**City of Portland, Maine - Building or Use Permit Application**  
 389 Congress Street, 04101 Tel: (207) 874-8703, Fax: (207) 874-8716

<b>Permit No:</b> 09-1188	<b>Issue Date:</b>	<b>CBL:</b> 186 D012001
------------------------------	--------------------	----------------------------

<b>Past Use:</b> Single Family Home	<b>Proposed Use:</b> Single Family Home - Raise roof on part of structure to create habitable space on the second floor.	<b>Permit Fee:</b> \$420.00	<b>Cost of Work:</b> \$40,000.00	<b>CEO District:</b> 3
<b>Proposed Project Description:</b> Raise roof on part of structure to create habitable space on the second floor.		<b>FIRE DEPT:</b> <input type="checkbox"/> Approved <input type="checkbox"/> Denied	<b>INSPECTION:</b> Use Group: Type	
		Signature:	Signature:	
<b>PEDESTRIAN ACTIVITIES DISTRICT (P.A.D.)</b>				
Action <input type="checkbox"/> Approved <input type="checkbox"/> Approved w/Condition <input type="checkbox"/> Denied				
Signature: Date:

<b>Dept:</b> Zoning	<b>Status:</b> Approved with Conditions	<b>Reviewer:</b> Ann Machado	<b>Approval Date:</b> 10/29/2009
<b>Note:</b> Original application was to raise the roof over part of the building, but change i

AMENDED ROOF STYLE CHANGE WE CABLE ROOF
TO HIP ROOF (ELEVATION)

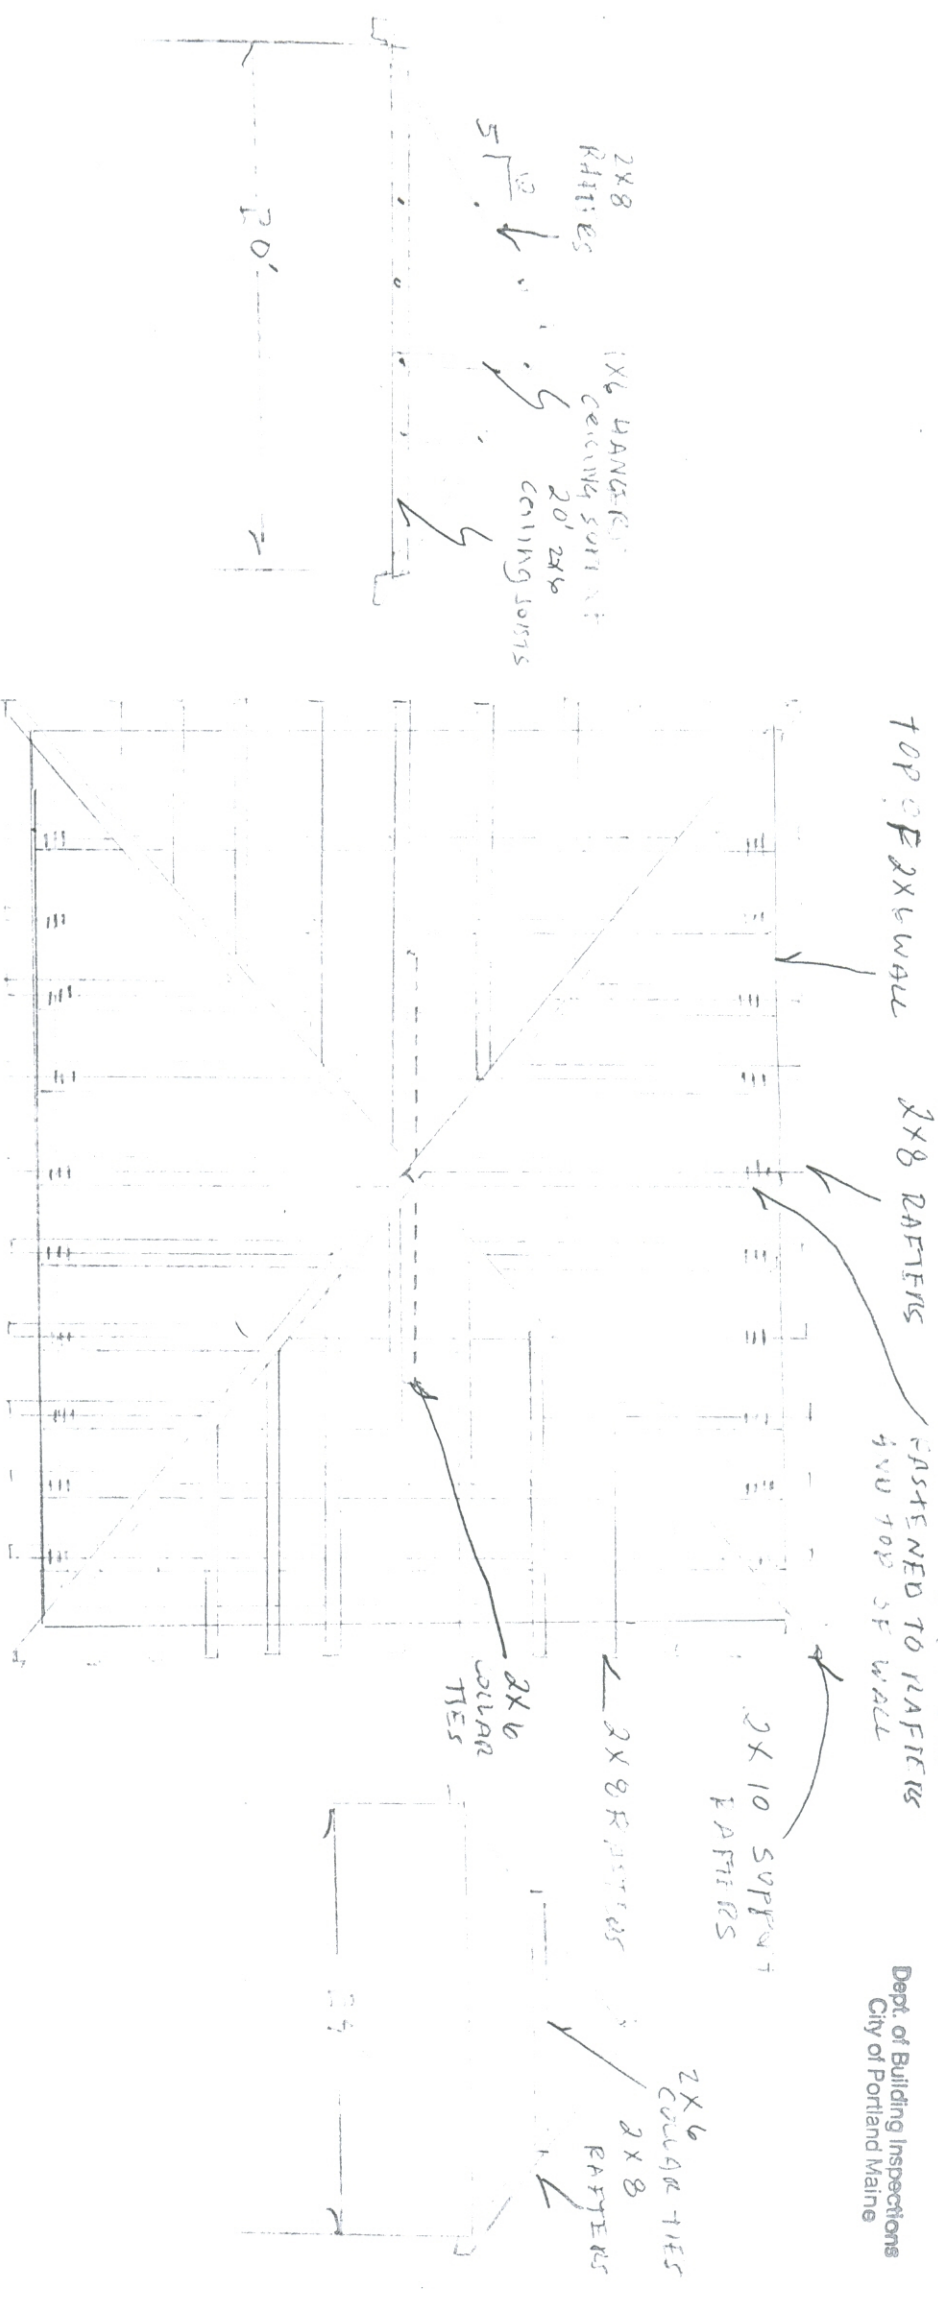
<b>Comments:</b>
10/28/2009-amachado: Left vcm for Donny Nevers, contractor. Structure doesn't meet the rear setback of 18'. Using sectin 14-436(b) the extra living space must be created by raising the existing roof configuration. What is being proposed is not keeping the existing rof configurtion.
10/29/2009-amachado: Donny Nevers brought in revised plan to change the gable roof to a hip roof.
